**KIRKLEES METROPOLITAN COUNCIL
INVESTMENT & REGENERATION SERVICE**

**DELEGATED DECISION TO DETERMINE PLANNING APPLICATIONS TO
CARRY OUT DEVELOPMENT WITHOUT COMPLIANCE WITH PLANNING
CONDITIONS PREVIOUSLY ATTACHED**

Reference No:	2025/70/92155/E
Site Address:	37, Tetley Drive, Birkenshaw, BD11 2NB
Description:	Variation condition 2 (plans) on previous permission 2024/93338 for erection of two storey side extension with front porch
Recommending Officer:	Jennifer Booth

DECISION – VARIATION OF CONDITION APPROVED

**DRAWING TITLE**  
Proposed Plans and Elevations - Option 1

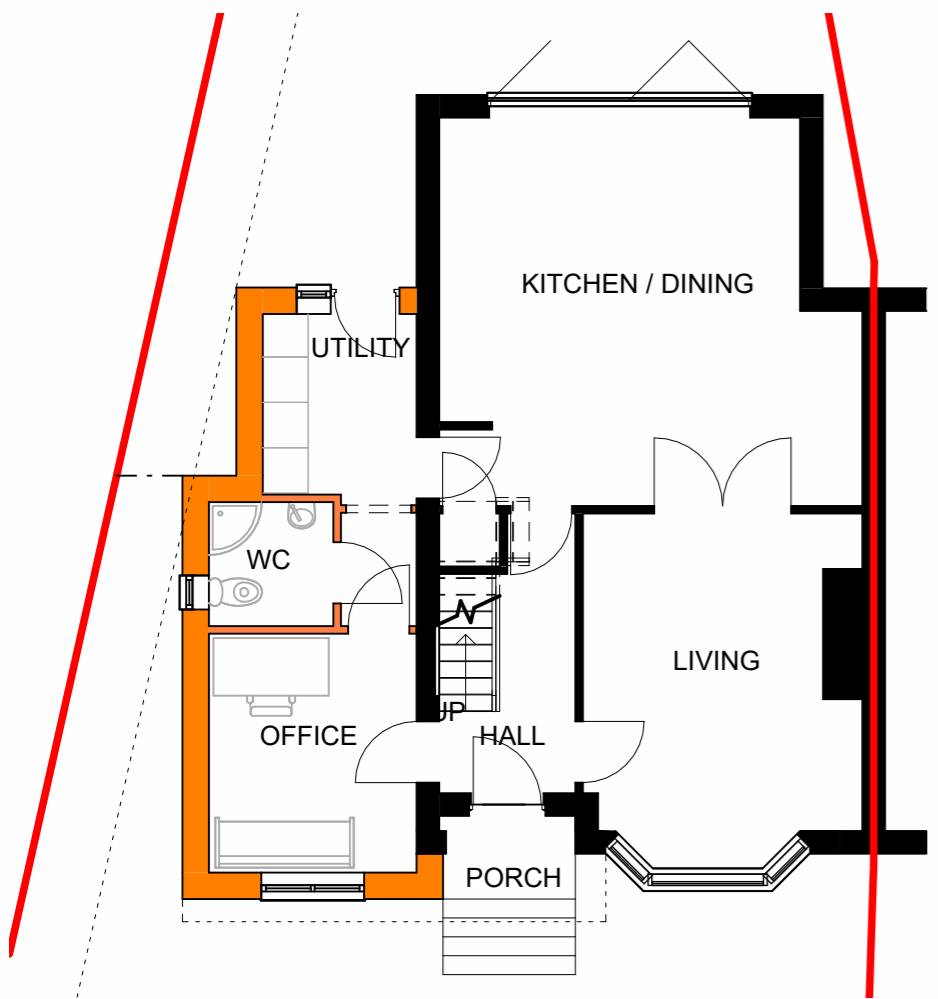
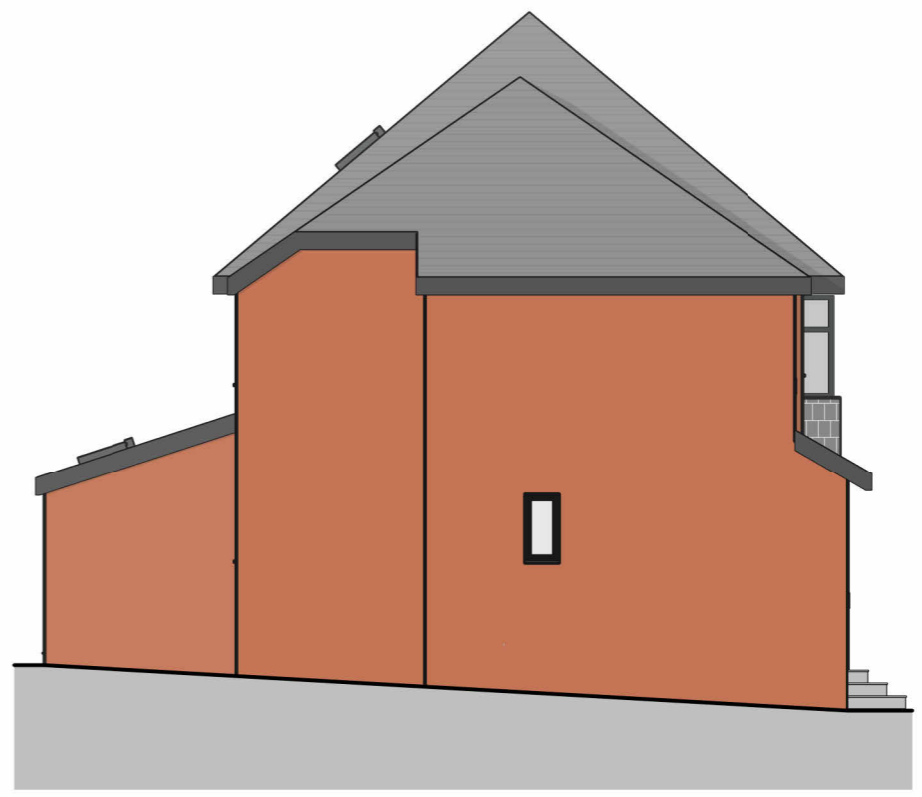
The alterations proposed to the plans are for the side extension. The projection to the side at the front would be reduced to 3.1m, extending back for 5.6m, then stepping in to a 2.5m projection for the remaining 2.5m. The roof form would still be pitched and a 1m gap would be retained to the side boundary. There would be a fractional set back at first floor.

The side extension has been altered from the angled design previously proposed with a slight reduction in width. The first floor of the side extension would be fractionally set back from the front elevation of the dwelling with the roof form being set down for the main roof and a gap of over 1m would be retained to the side boundary. Whilst the limited set back is less than ideal, it can be justified given the angled relationship with the neighbouring property and the position of the two storey property on the entrance into a street with bungalows. Furthermore, it is noted that the adjoining property has their own two storey side extension which does not have a set back. The side extension would be proportionate to the main house. The scale and design are therefore considered to be acceptable. The materials proposed include the use of brick for the walling with tiles for the roof covering which would match the main house. The side extension is therefore considered to be acceptable in terms of visual amenity.

The adjacent property is a bungalow with limited openings in the side elevation. Given the spatial relationship, which is angled, and the alignment of the properties, the proposed side extension would have limited potential to result in any overshadowing, overbearing or overlooking.
